DELEGATED DETAILS DECISION

Report of the Head of Planning, Building Control, Sport & Green Spaces

Address RAF WEST RUSLIP HIGH ROAD ICKENHAM

LBH Ref Nos: **38402/APP/2015/851**

20667_A_E_MAT

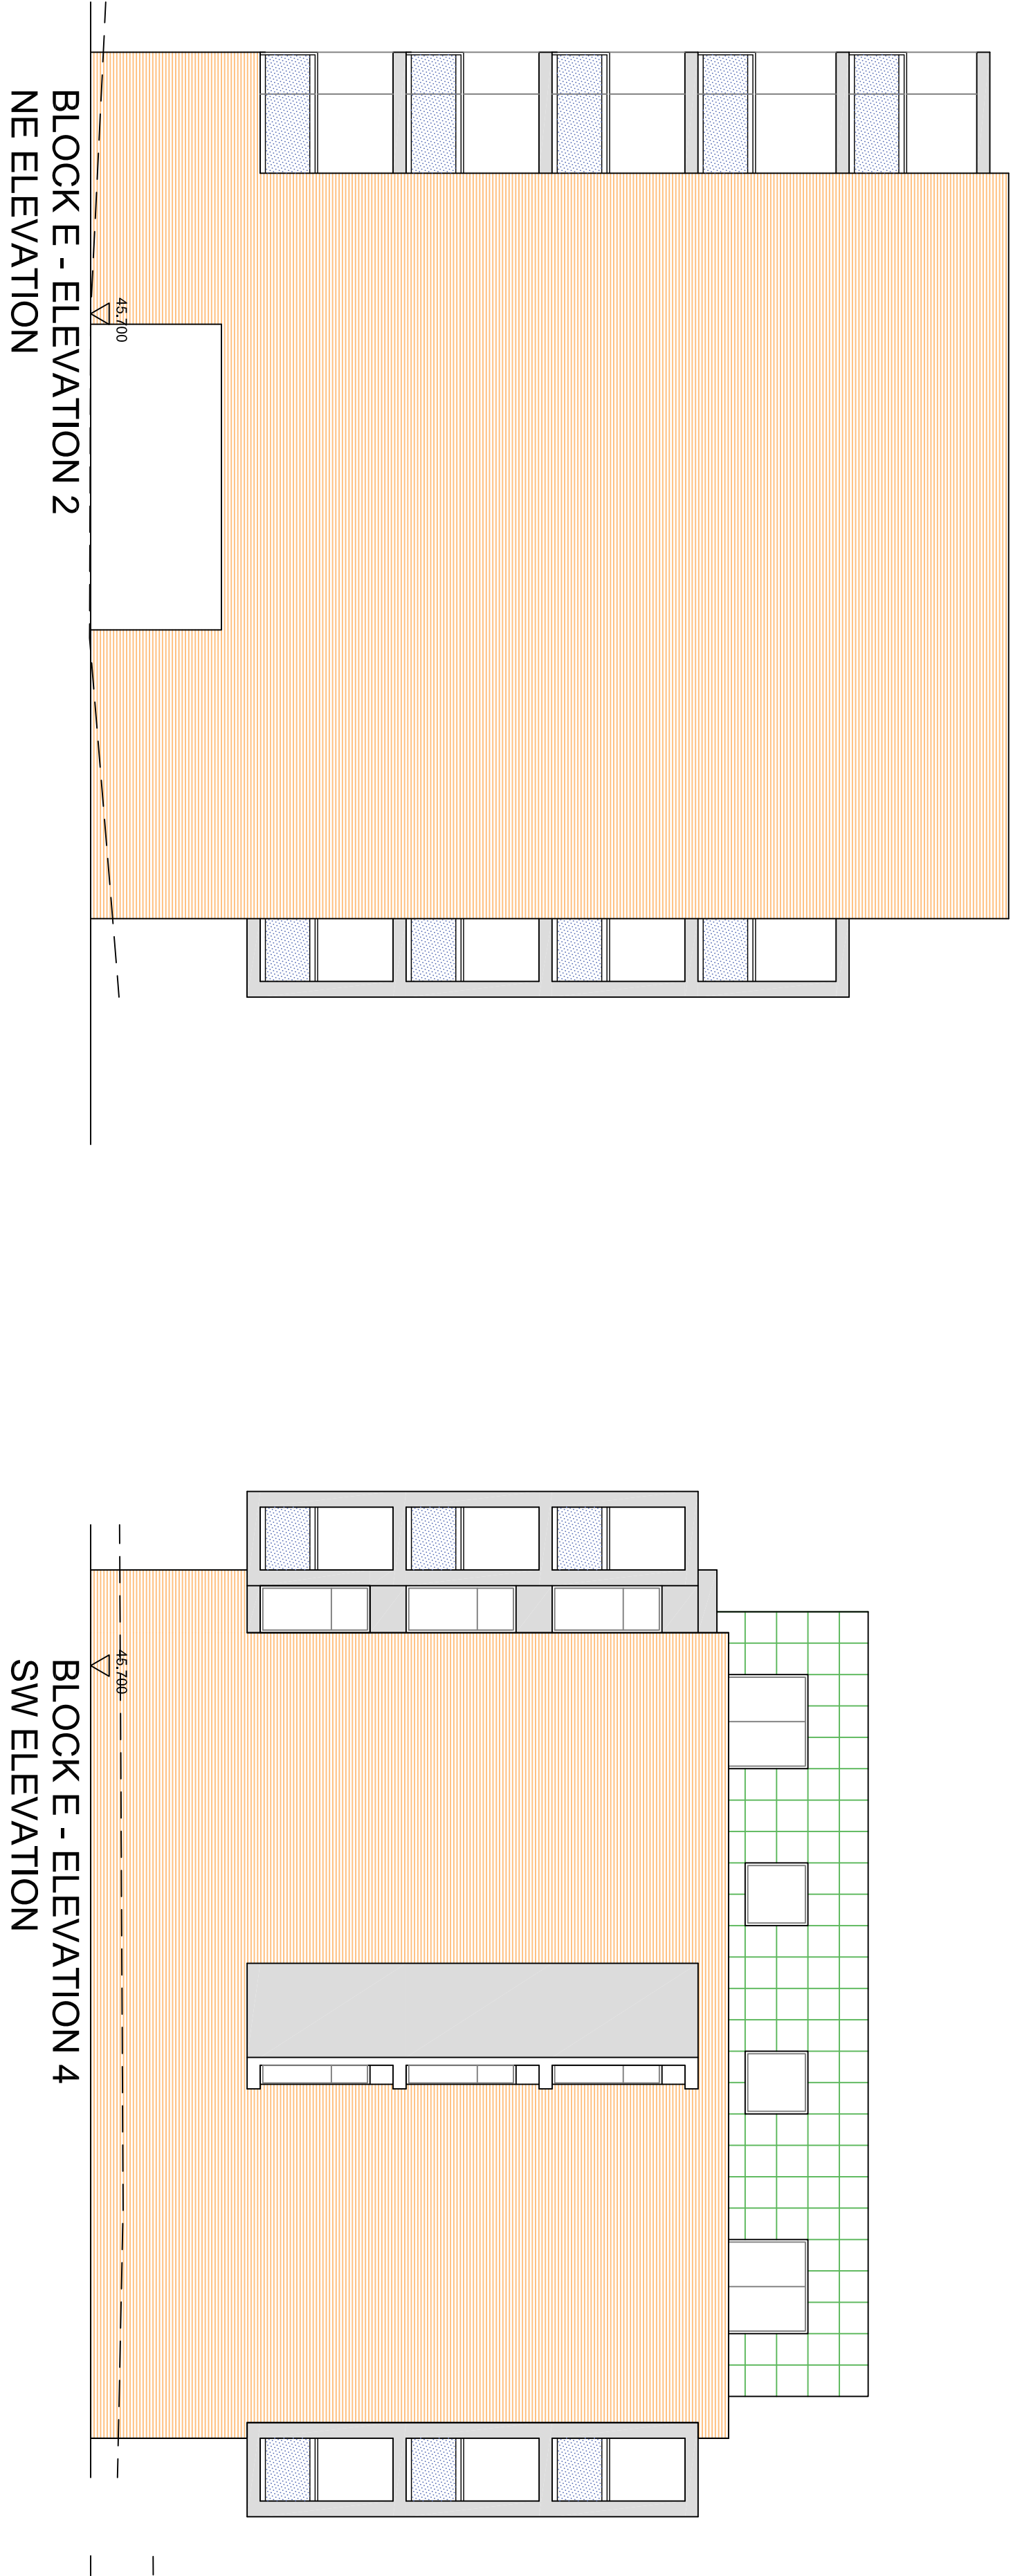
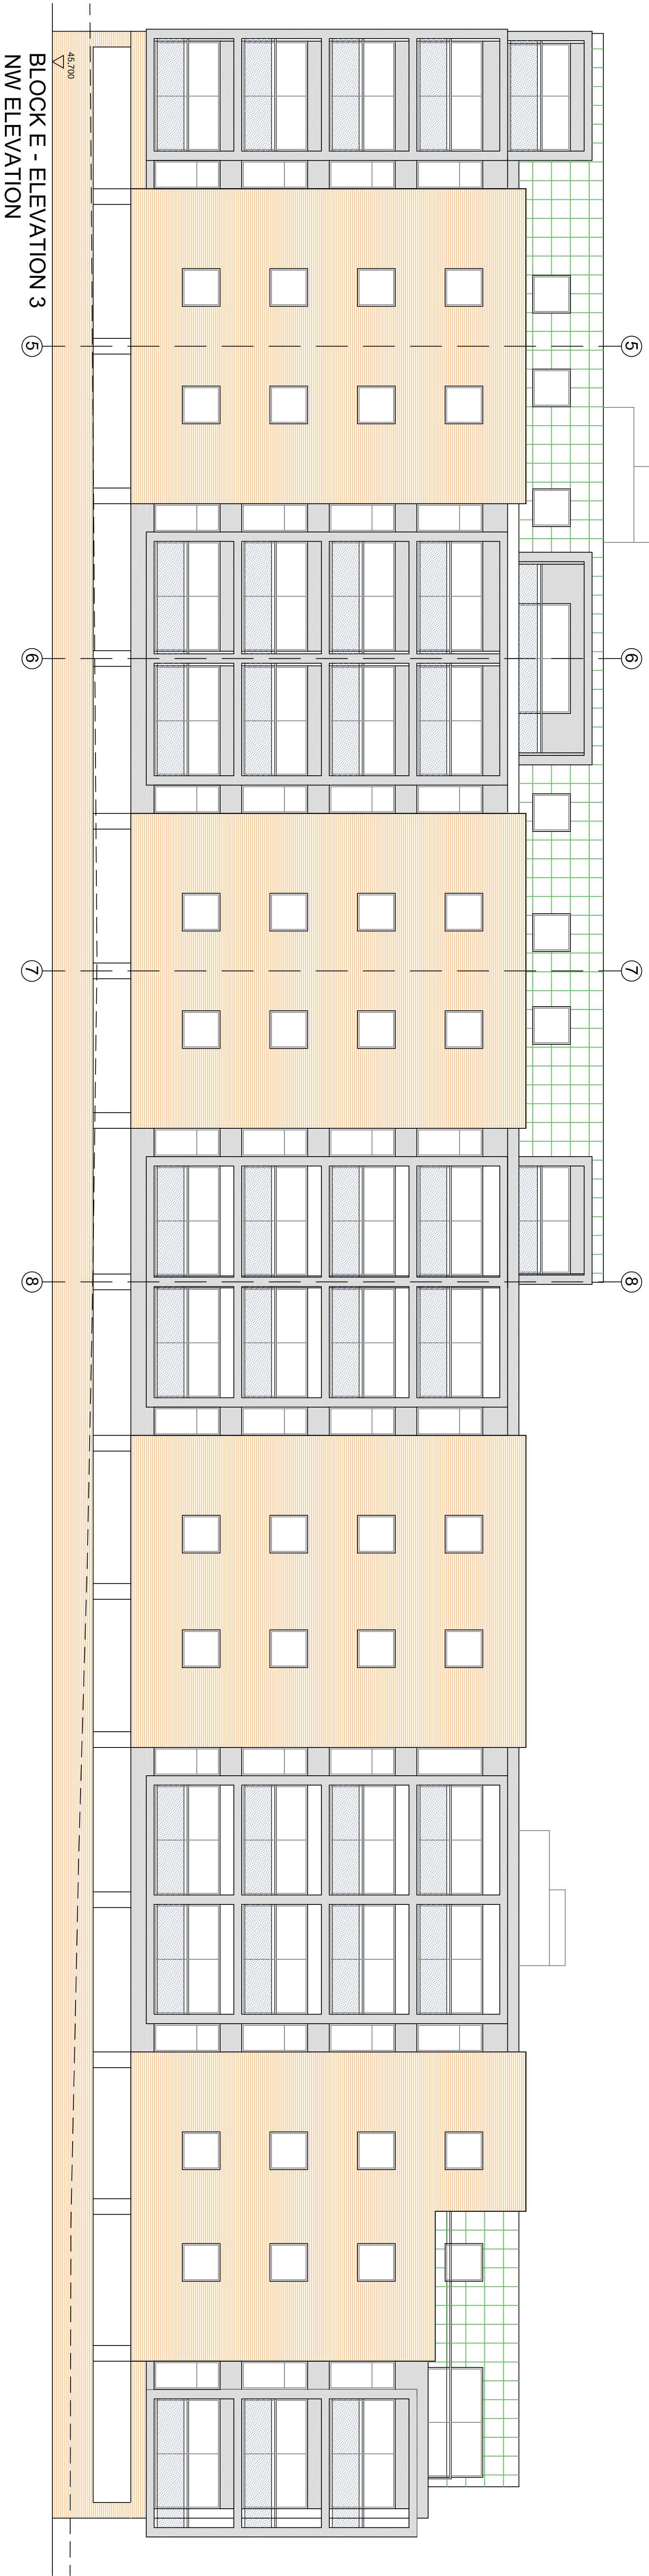
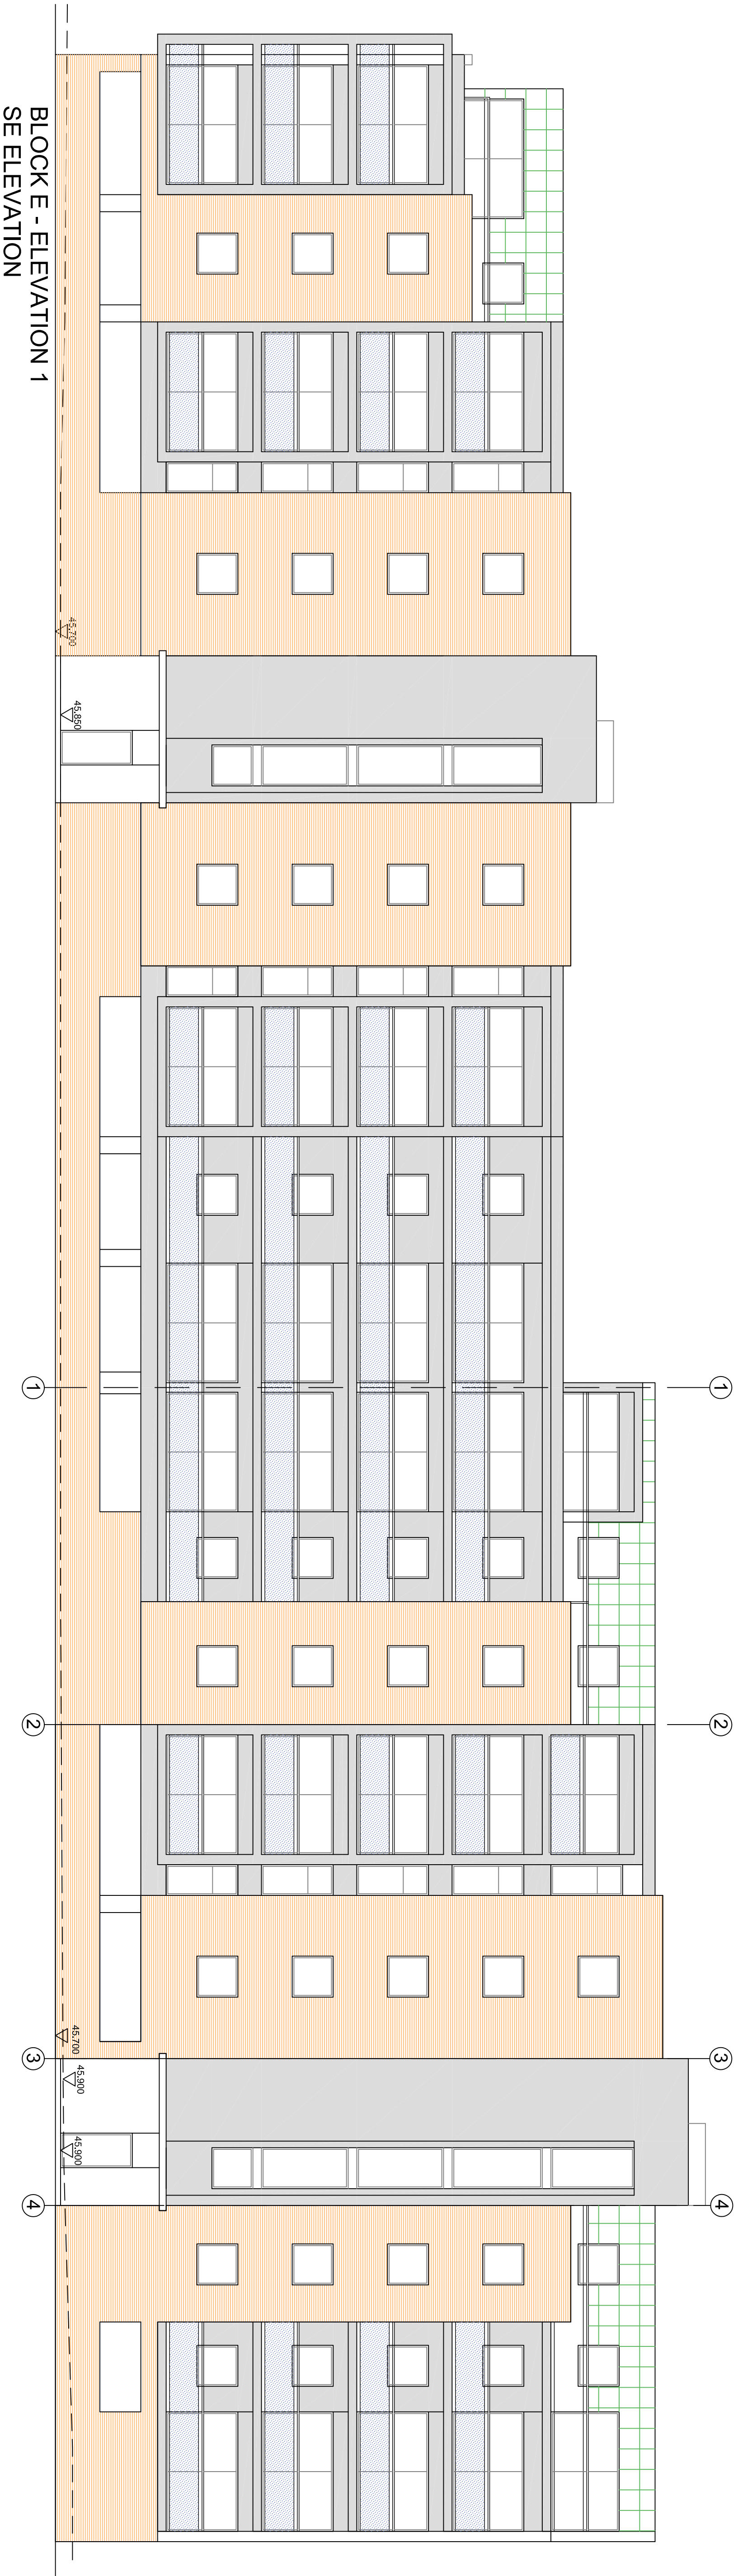
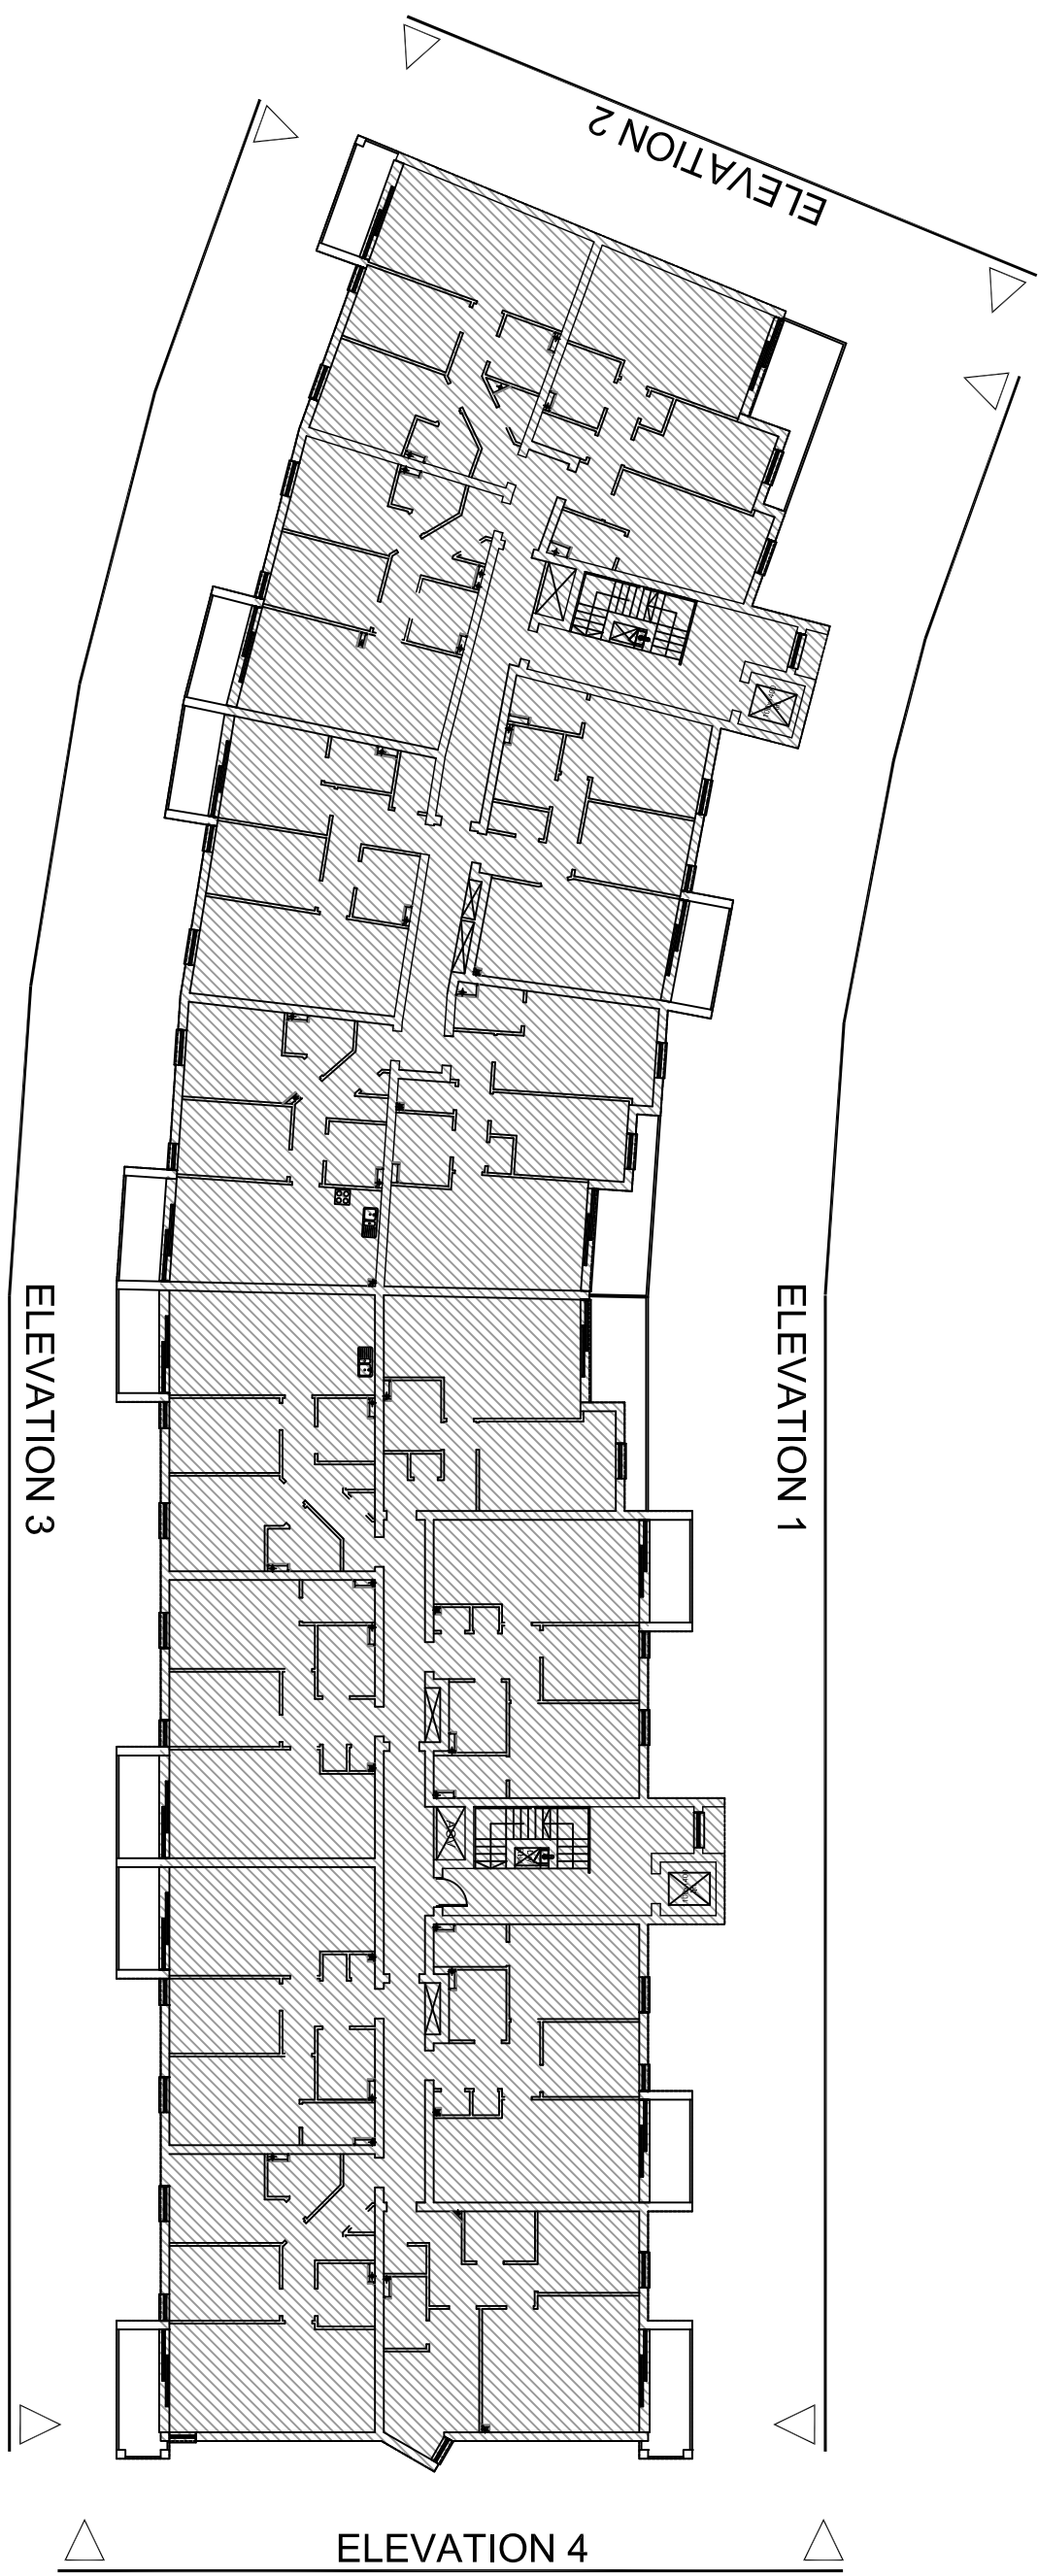
There are, however, concerns re the materials for the two blocks of flats. Whilst these appear to be the same as approved for the existing block adjacent to the

station, this structure as built does now appear to be overly prominent in the street scheme, not only because of its height and bulk but also because of its light coloured rather bland looking materials. If possible, the use of these for this phase should be reconsidered, and a darker more textured brick and a more recessive cladding colour for the upper floor used.

I still think the proposed yellow bricks are not the best, the bricks used on the other side of the site look better, with more texture and a subtle variety in colour. But I don't know how far we can object to the bricks as proposed if we have agreed them for use on this part of the site previously.

The revised proposed brick for use on the flats is acceptable and the other changes to the materials for the houses are also acceptable.

Following the Urban Design/Conservation Officer's initial comments, the bricks for the flatted blocks have been amended and are now slightly more textured. The tiles have been approved previously on the adjoining phases. The agent has also confirmed that the weatherboarding on the projecting bays which are only present on 6 houses would be Eternit Cedral, colour - white. The Urban Design/Conservation Officer is satisfied with the proposed materials.
